**COMMUNITY SERVICES DEPARTMENT**  
PARK OPERATIONS ~ ENVIRONMENTAL SERVICES ~ RECREATION/CULTURAL SERVICES

October 17, 2022

**Subject: Falcon Meadows at Bent Grass Filing No. 4 Final Plat (SF-2223)**

Bent Grass Filing No.4

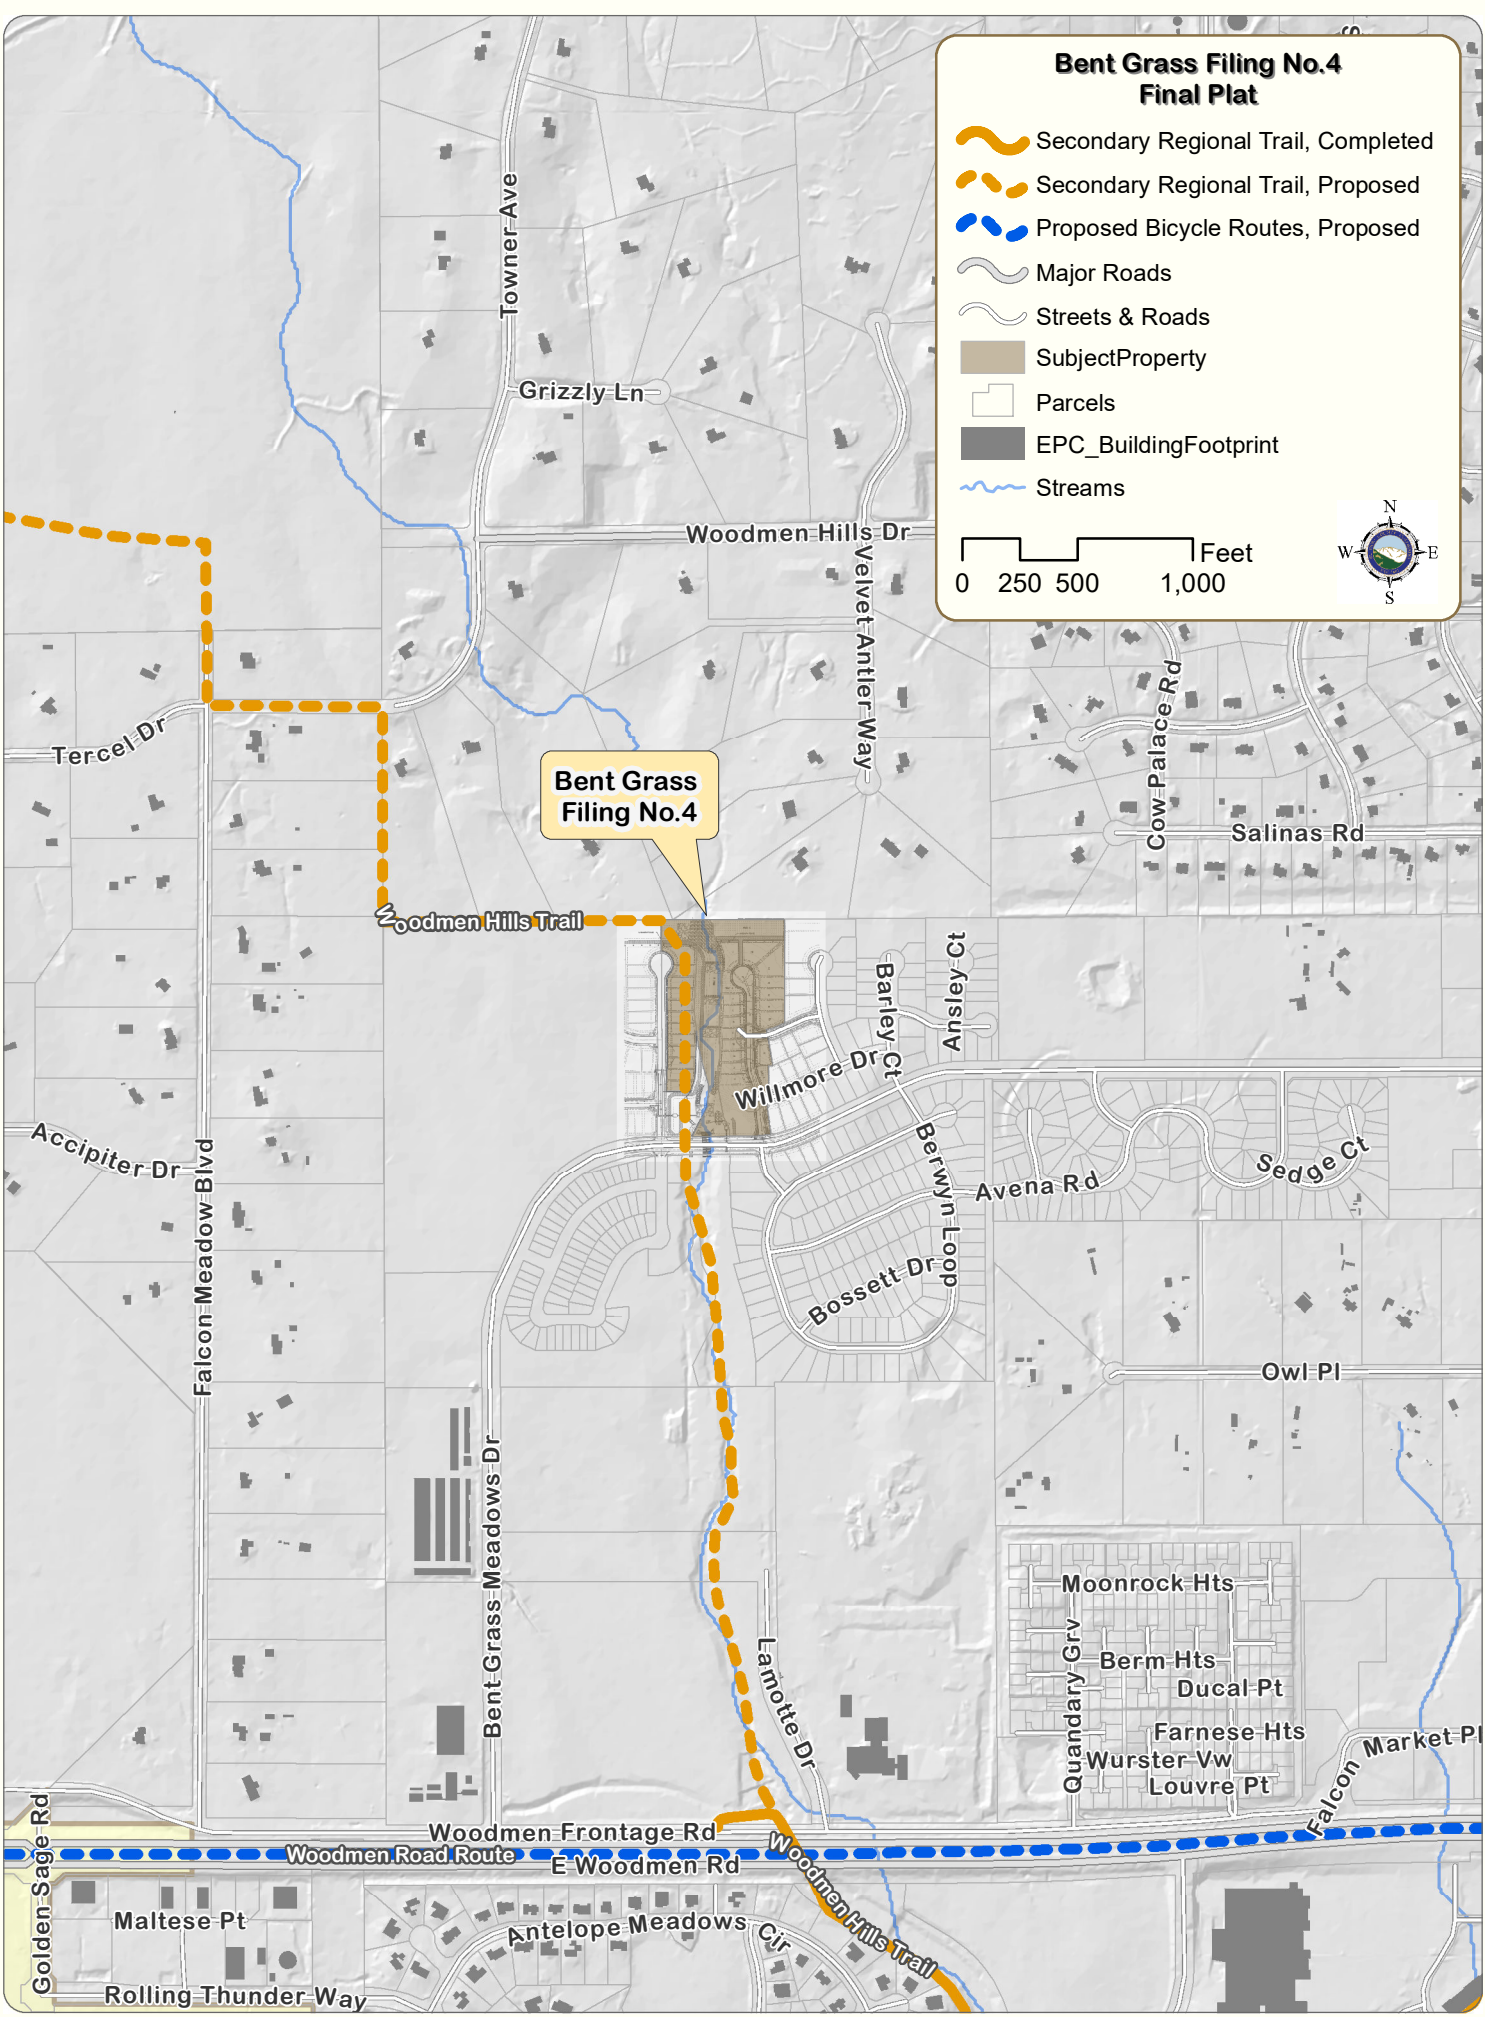
*The 2013 El Paso County Parks Master Plan shows the proposed Woodmen Hills Secondary Regional Trail running north and south through the west side of the Bent Grass Filing No. 4. Sections of the Woodmen Hills Secondary Regional Trail are already shown as recorded on adjacent filings north and south of Filing No.4.*

*County Parks requests trail easements where development projects impact proposed County trails. As it pertains to this application, the County requests that the landowner provide a 25-foot-wide public trail easement along the west side of the development, through Tracts A and B that will allow for the construction and maintenance by El Paso County of the Woodmen Hills Secondary Regional Trail.*

*The Park Advisory Board recommends that the Planning Commission and the Board of County Commissioners include the following conditions when considering and/or approving the Falcon Meadows at Bent Grass Filing No. 4 Final Plat: (1) designate and provide to El Paso County a 25-foot-wide public trail easement through Tract A and B that allows for the construction and maintenance by El Paso County of the Woodmen Hills Secondary Regional Trail, and dedicate the easement to El Paso County prior to the recording of the forthcoming Final Plat (2) require fees in lieu of land dedication for regional park purposes in the amount of \$17,940, and urban park fees in the amount of \$11,310 will be required at time of the recording of the final plat(s).*
